An  
Bord  
Pleanála

Board Direction  
ABP-312339-21

**WHEREAS** a question has arisen as to whether a shed of 19.9 square metres to the rear of a house at Doogan's Warren, Rosslare Strand, Co. Wexford is or is not development or is or is not exempted development:

**NOW THEREFORE** An Bord Pleanála, in exercise of the powers conferred on it by section 5 (3) (a) of the 2000 Act, hereby decides that erection of a shed of 19.9 square metres to the rear of a house at Doogan’s Warren, Rosslare Strand, Co. Wexford is development and is not exempted development.

C-115

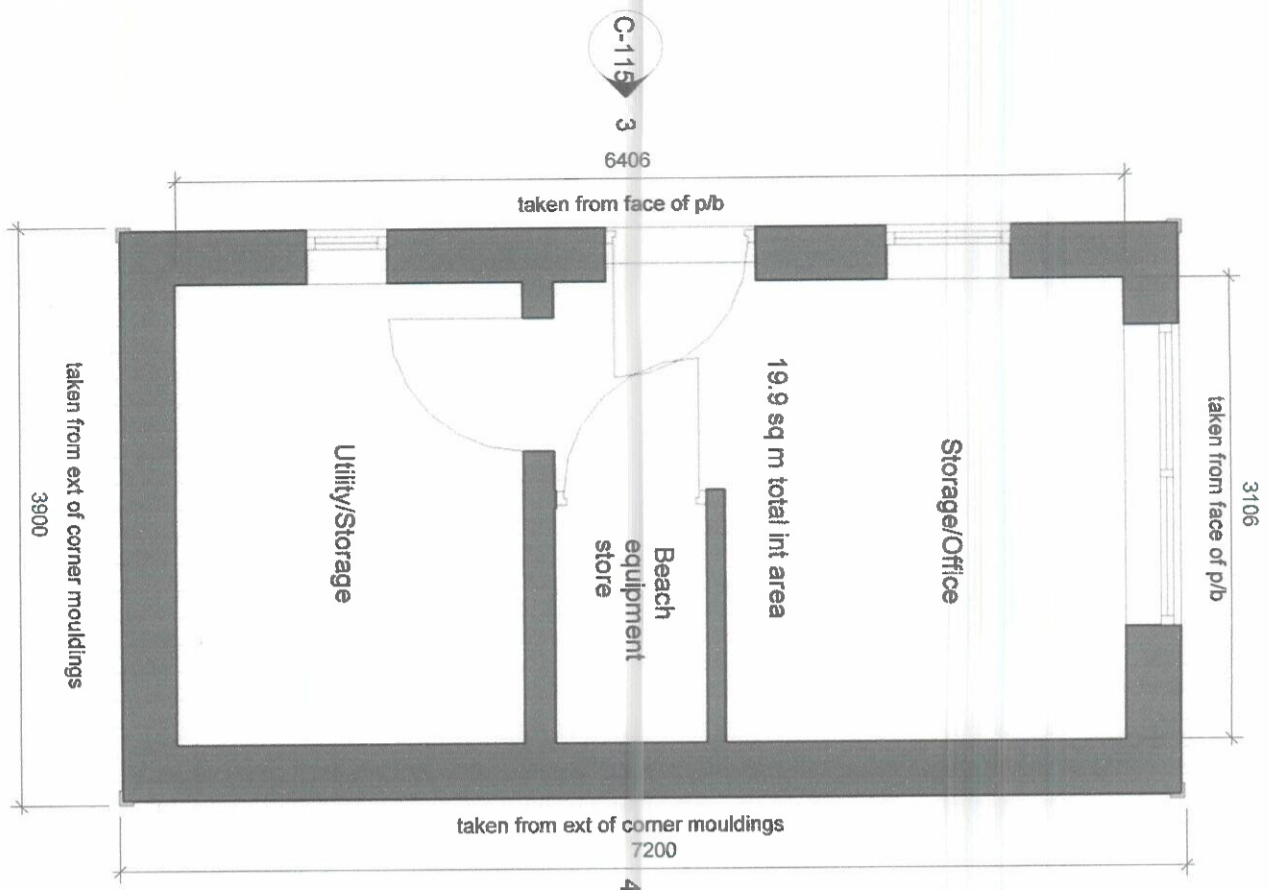
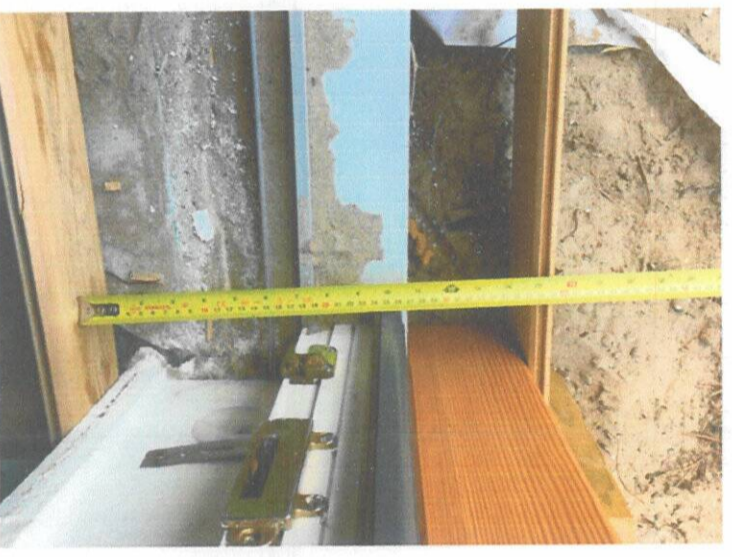
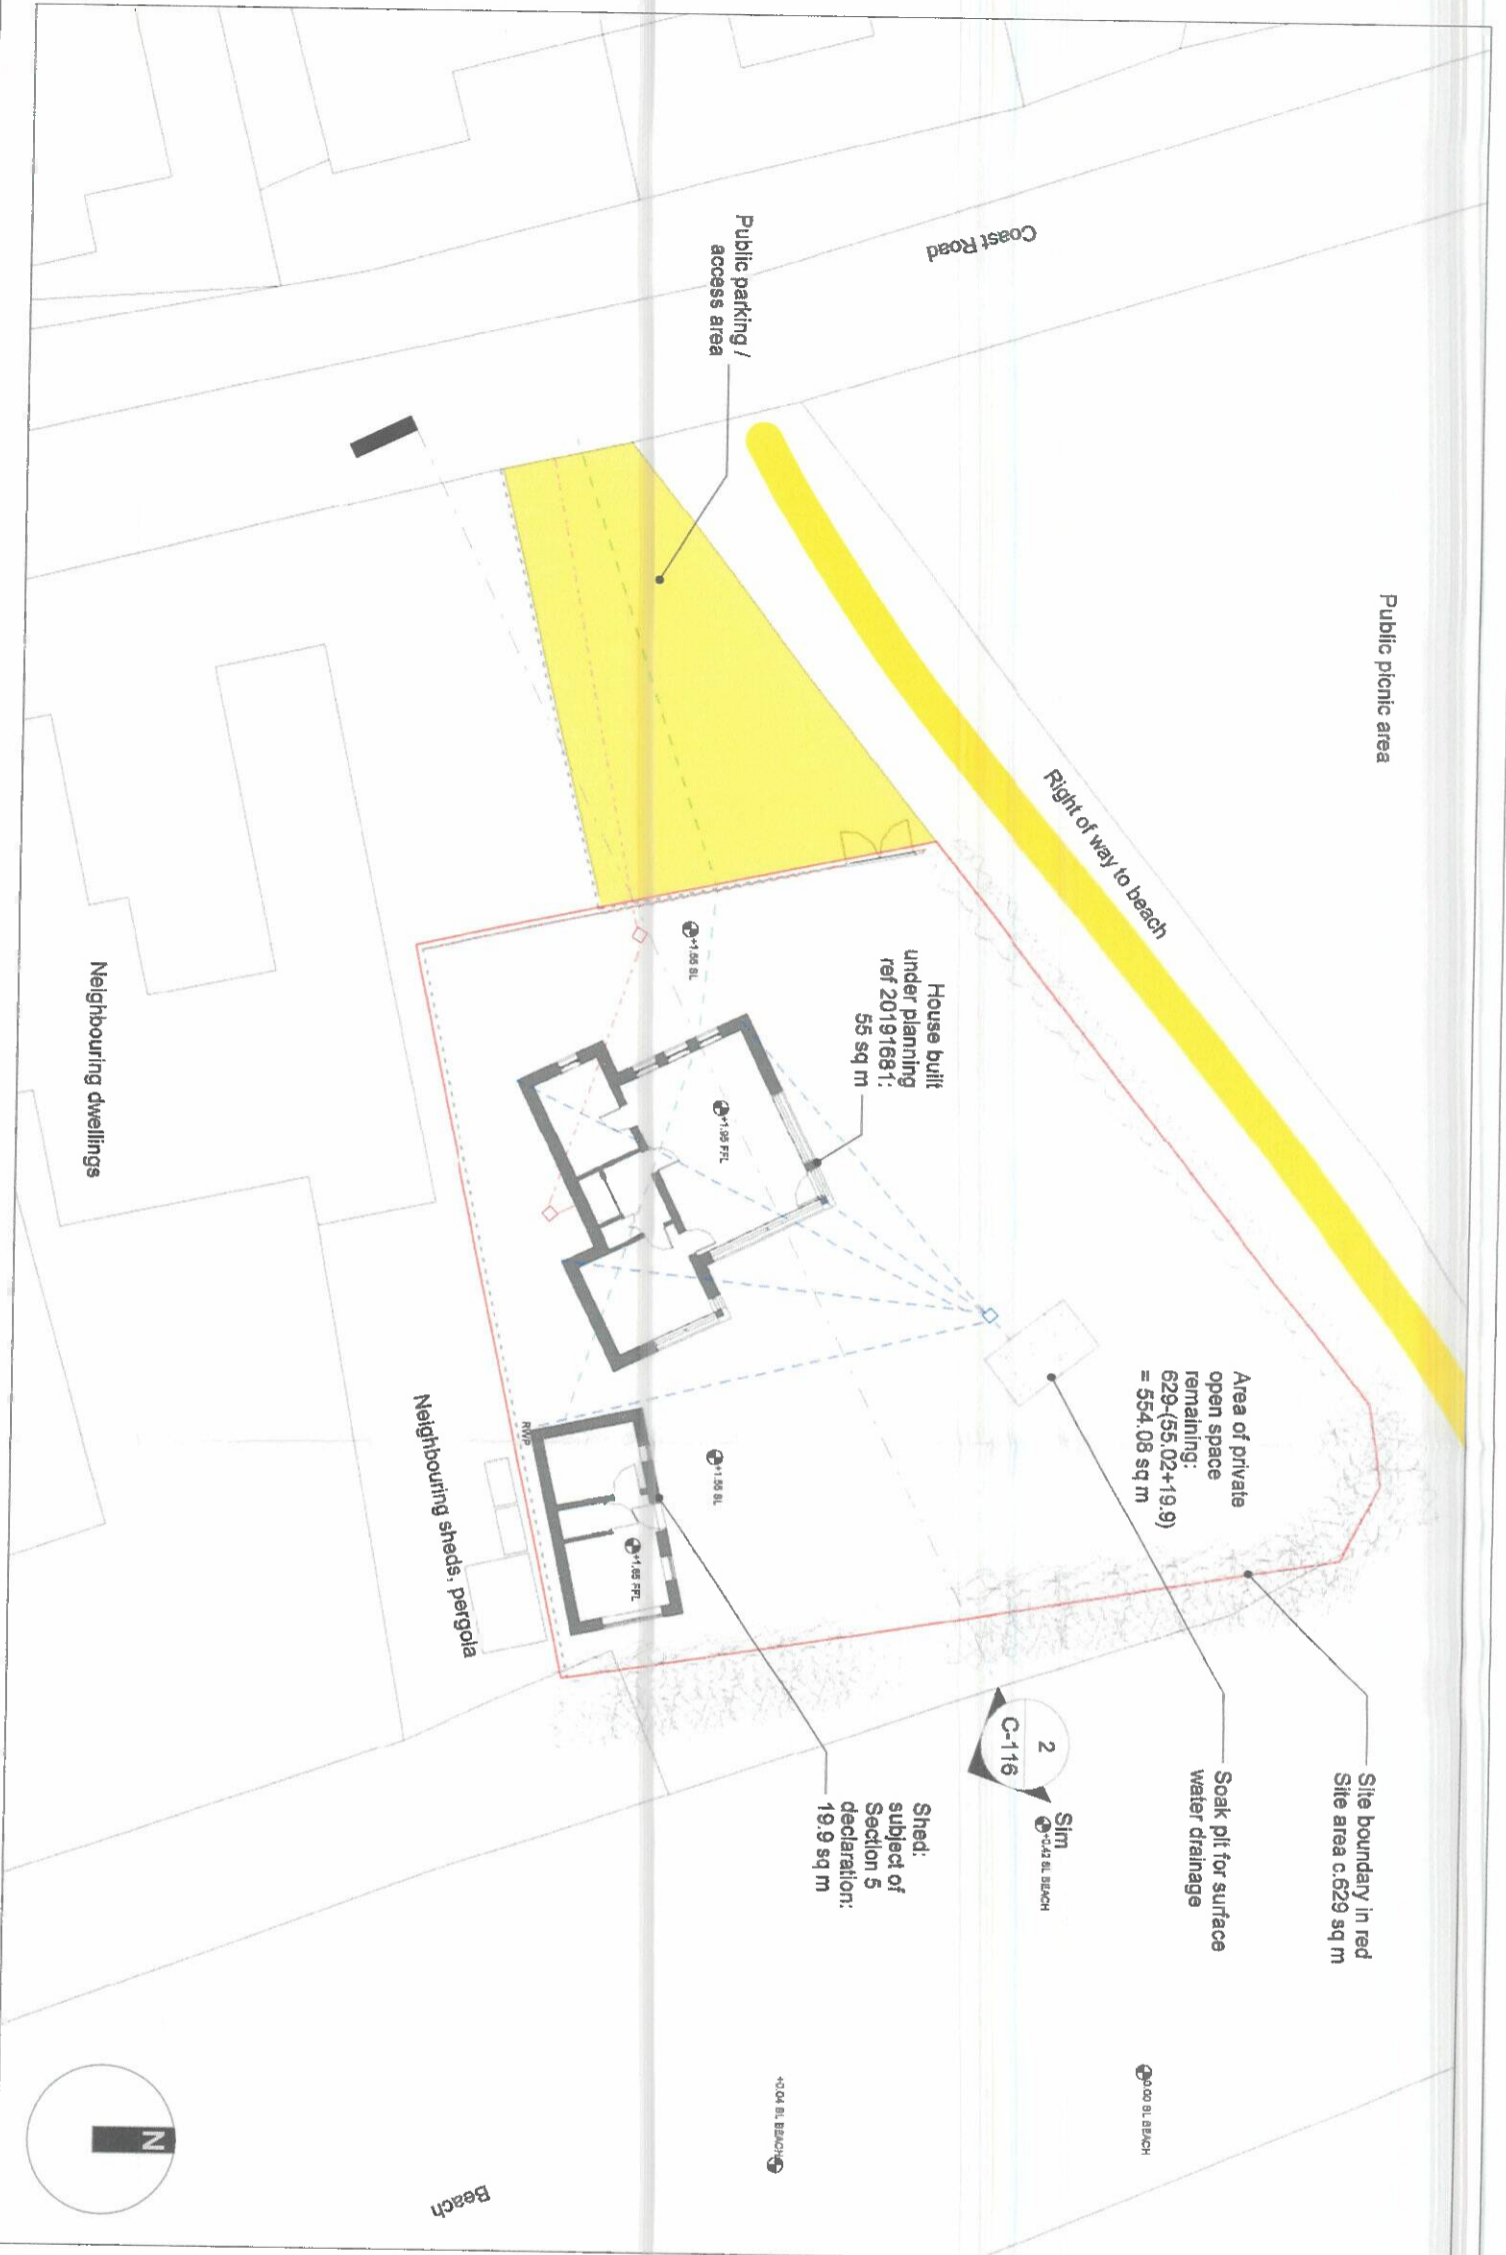
the shed does not fall within the scope of Class 3 of Part 1 of Schedule 2 of the Planning and Development Regulations 2001, as amended, as it was erected at the same time as the house.
